**PROOF OF EVIDENCE**  
of  
**DAVID HUSKISSON Dip (LA) Glos CMLI**  
relating to  
**LANDSCAPE AND VISUAL EFFECTS**  
on behalf of  
**CHERWELL DISTRICT COUNCIL**

**Appeal against the refusal of Cherwell District Council  
to grant planning permission for  
Redevelopment of part of a golf course to provide new leisure resort (sui generis)  
incorporating waterpark, family entertainment centre, hotel, conferencing facilities  
and restaurants with associated access, parking and landscaping on land  
to the east of M40 and south of A4095, Chesterton, Bicester, Oxon**

**Local Planning Authority Reference: 19/02550/F  
Planning Inspectorate Reference: APP/C3105/W/20/3259189**

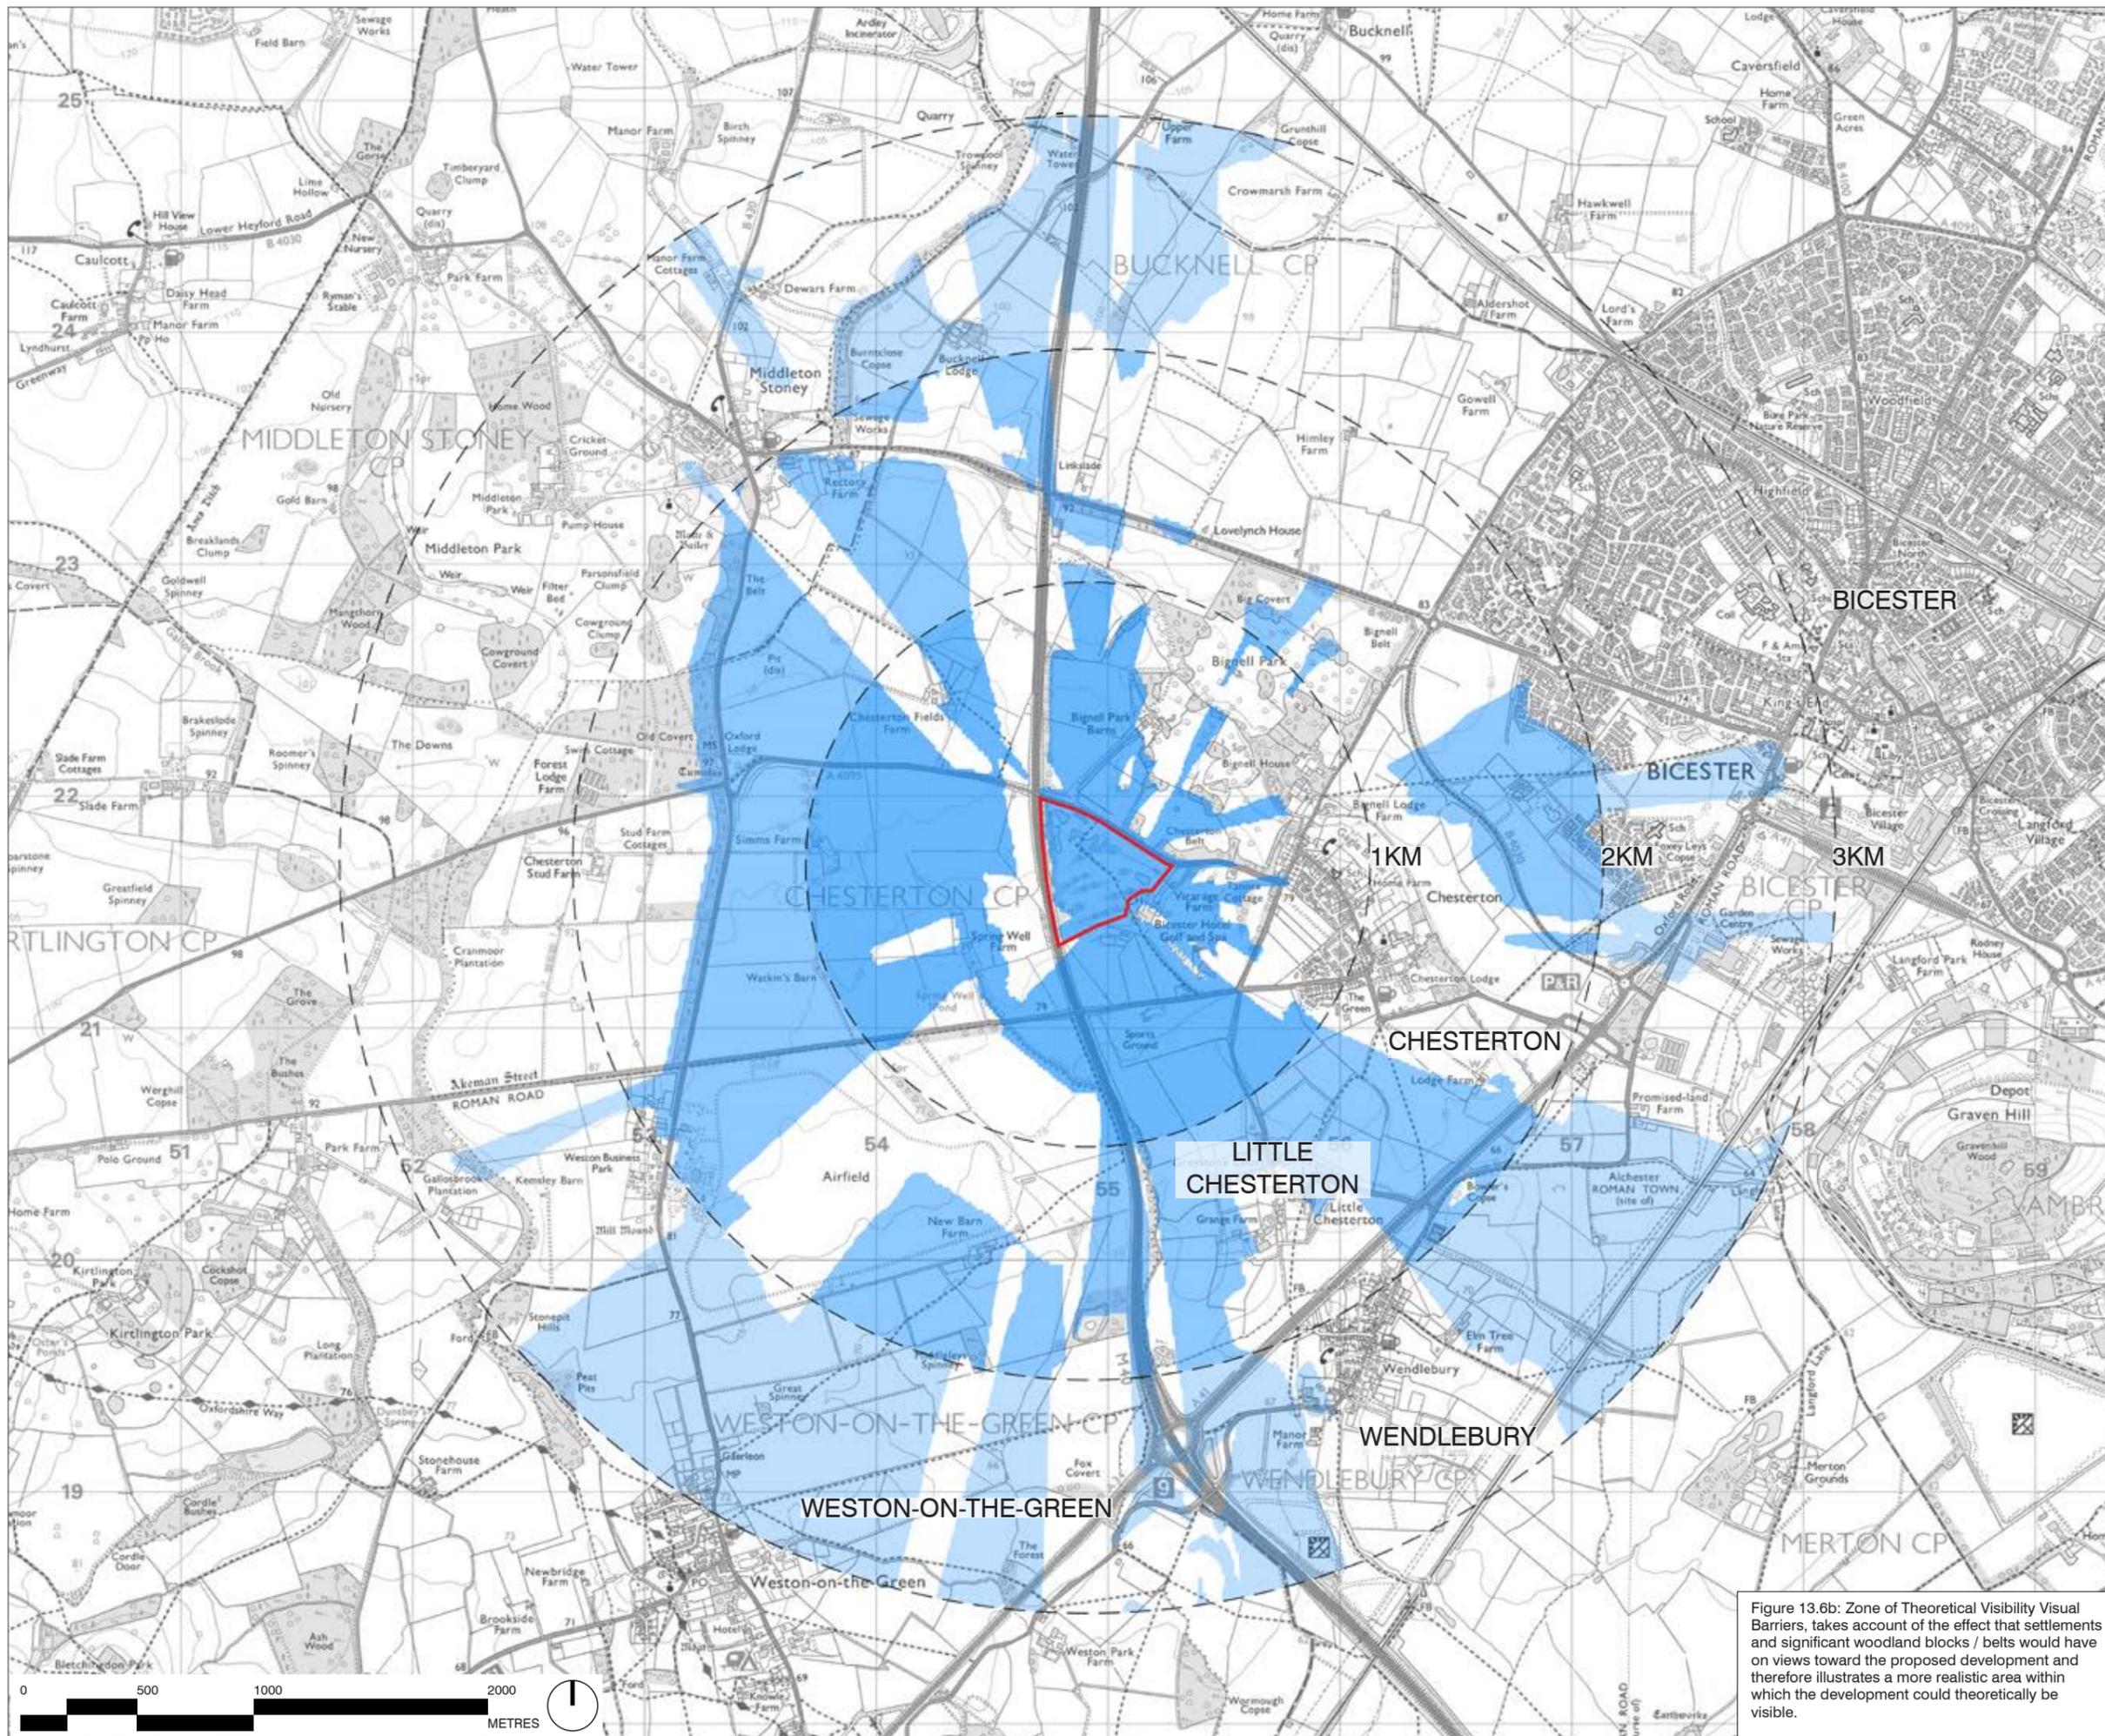
2.22 LVIA Figs 13.6a and 13.6b show the main areas of potential visibility, based on a bare earth ZTV and a ZTV with existing visual barriers factored in respectively. For the purposes of my evidence, I have been mainly concerned with those views on and in close proximity to the site, so I have not tested the extent of the submitted ZTVs but Fig 13.6b seems plausible based on my site inspection but as I caveat below. I note from the LVIA methodology dealing with the ZTVs at A2.6, 4<sup>th</sup> bullet, that *“the developable volume is set at the various heights shown on the EPR plans and elevations”*. I have been given to understand by the appellant that this is based on information shown on plan 875-EPR-00-05-DR-A-TP-0204 combined with the proposed FFL of 82.700 AOD indicated on the landscape plans.

2.23 The ZTV methodology adopted a 12.0m height for modelling woodland in the area. The plan suggests that height this was adopted for the whole of the planting along the M40 site boundary whereas the Arboricultural Impact Assessment (**CD1-3**) categorises substantial lengths of trees cover along this boundary at less than 12.0m high so this flags up a note of caution in how this plan should be interpreted.

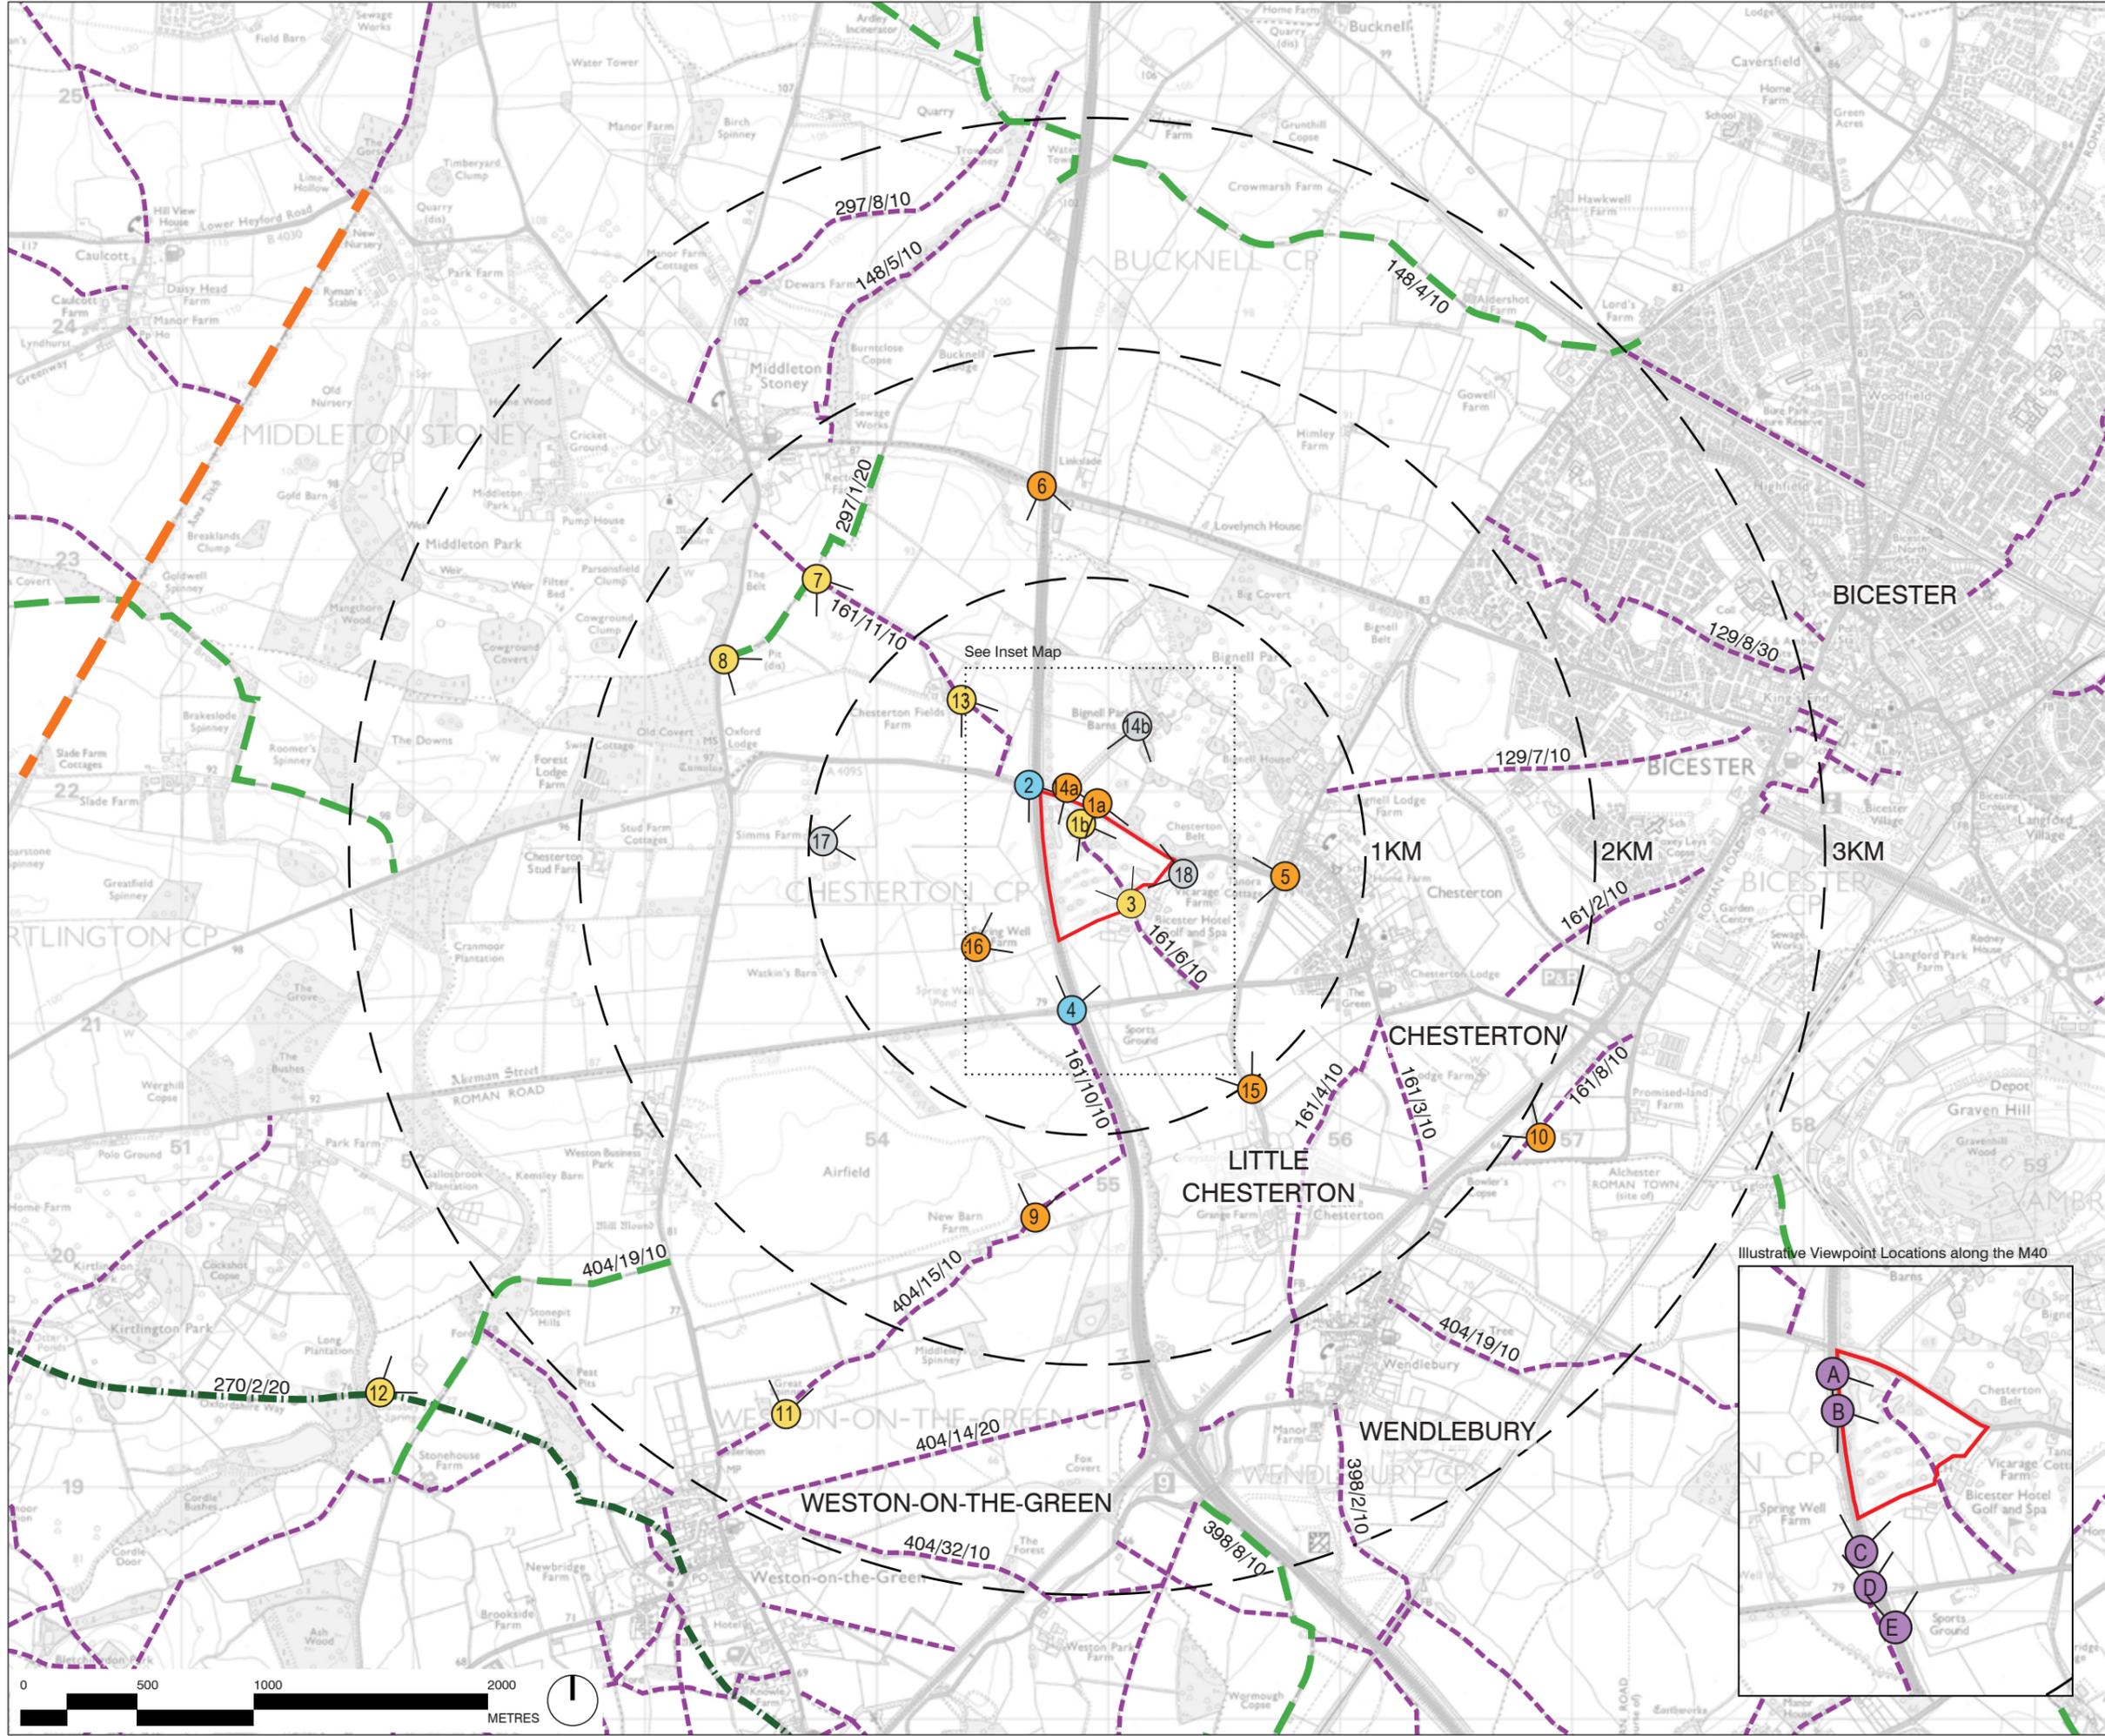
2.24 ZTV Fig 13.6b also adopts a 9.0m height as the cut off for modelling settlements in the area, which I consider is appropriate. In this regard, the Chesterton Conservation Area Appraisal (**CD7-1**) notes at 10.3, where it addresses scale and massing of the properties in the northern part of the conservation area, closest to the appeal site, that: *“all of 2 storeys in*
